PROJECT:
415 CUMBERLAND AVENUE
 415 CUMBERLAND AVENUE, PORTLAND, MAINE
 BOUNDARY & TOPOGRAPHIC SURVEY

In response to the **original CMP**, Tom offered the following comments:

In response to the **updated CMP**, Bruce offered the following comments:

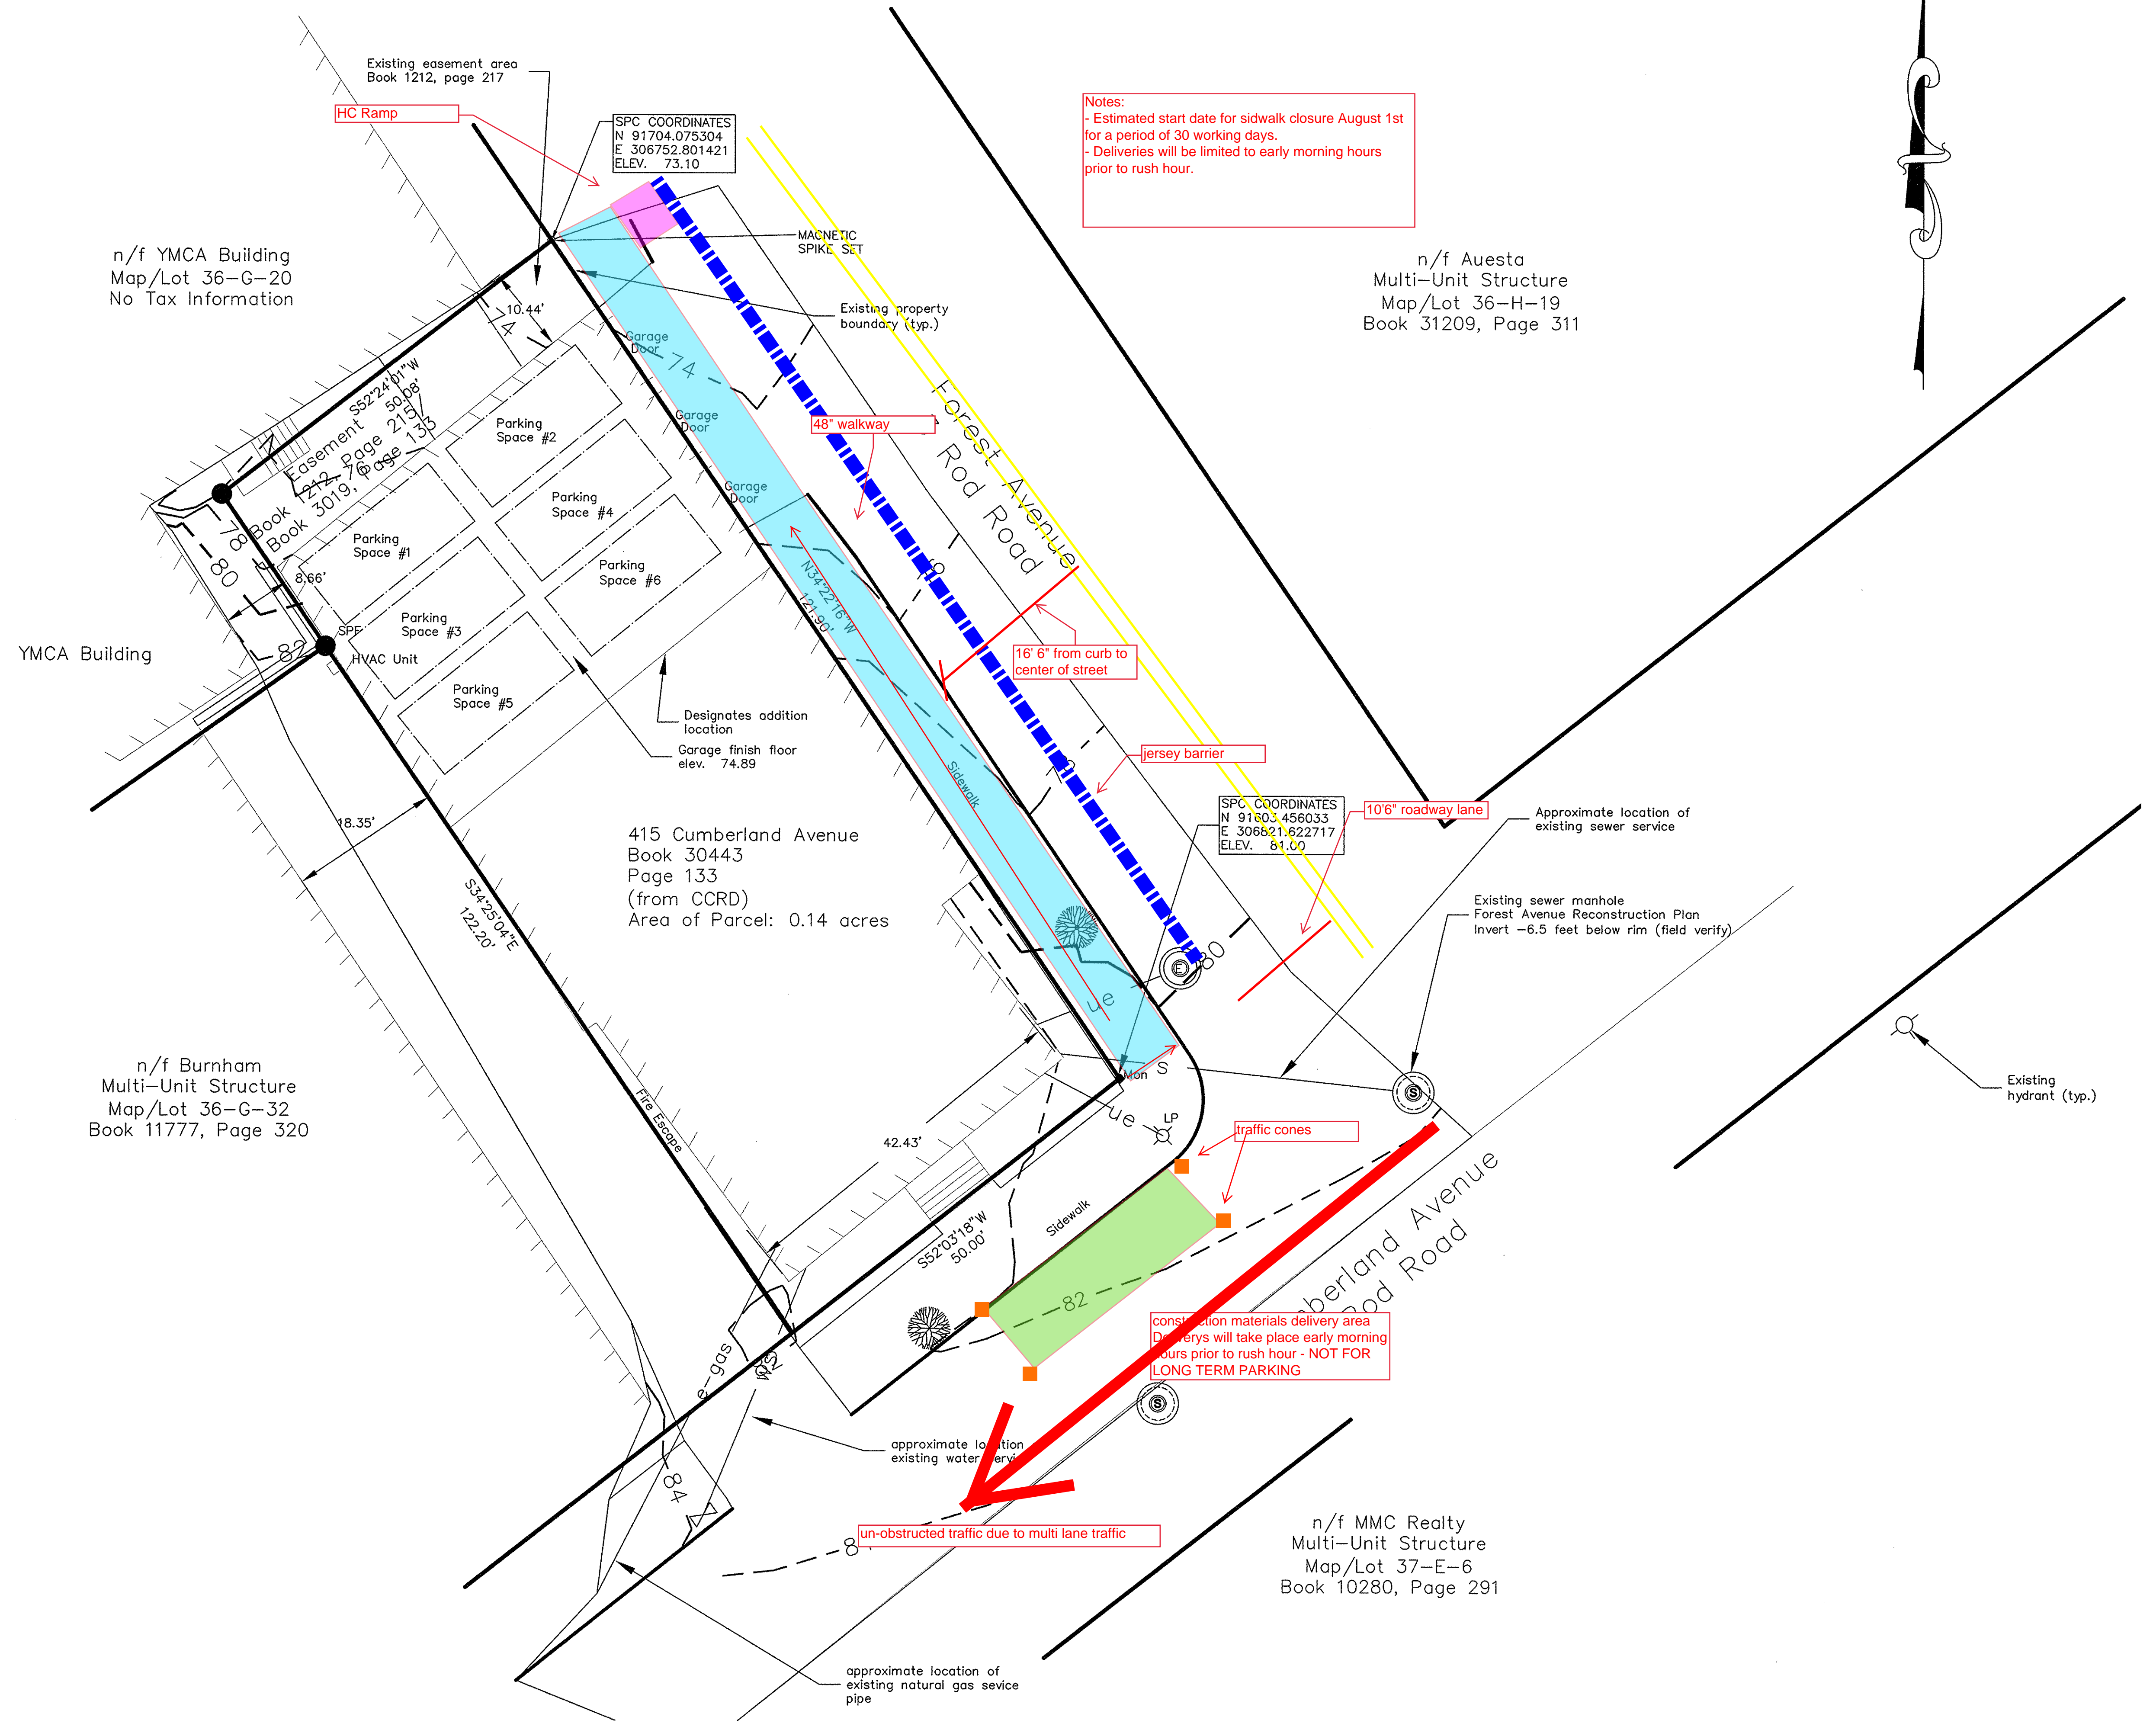
the sidewalk detour plan is not acceptable. All temporary detour routes need to be ADA compliant and make sense from a use perspective. If it can fit, it may make sense to provide a temporary facility with a barrier. I would also note that DPW would like the scope and duration of the sidewalk closure to be defined. DPW does not support the occupancy of a sidewalk and/or parking for an extended period of time and construction sequences shall be scheduled to minimize the duration of any occupancy. The applicant should also provide roadway width dimensions for the vehicle loading area on Cumberland Avenue.

- 1) I don't believe that 3' is sufficient for the pedestrian detour: 5' is our typical minimum but 4' should be our absolute minimum and needs to be fully usable width.

- 2) I don't believe the dimensions shown take into account, for example, the footprint of the jersey barriers themselves with is probably at least 1.5'-2' in width but should be verified. So the pedestrian detour, jersey barrier and travel lane (we likely want at least 10.5' - but should be checked with Jeremiah) likely won't fit within the 16' available between the curb and existing double-yellow center-line.

- 3) They also don't show how and where ADA-access is provided from the sidewalk in advance of their property to the pedestrian detour route (from the neighboring YMCA's dumpster driveway?).

- 4) I'll let others chime in on the use of Forest Ave at that location for delivery of materials "before rush hour" - there are specified hours for construction activity that I believe also include delivery of materials but I'm not positive on that front. Of course it would be advantageous for the deliveries to be then but I'm not sure it's permissible.

- 1) ramp (bituminous, tarp)
- 2) 4' width (increase of 1')
- 3) Account for width of jersey barrier (1.5?)
↳ spills over to width of travel lane.

4ft + 2ft → 10.5 ft roadway lane?

4) barrier continues to far. (blocks crosswalk across Forest) @ stop bar?

5) Not for long term parking.
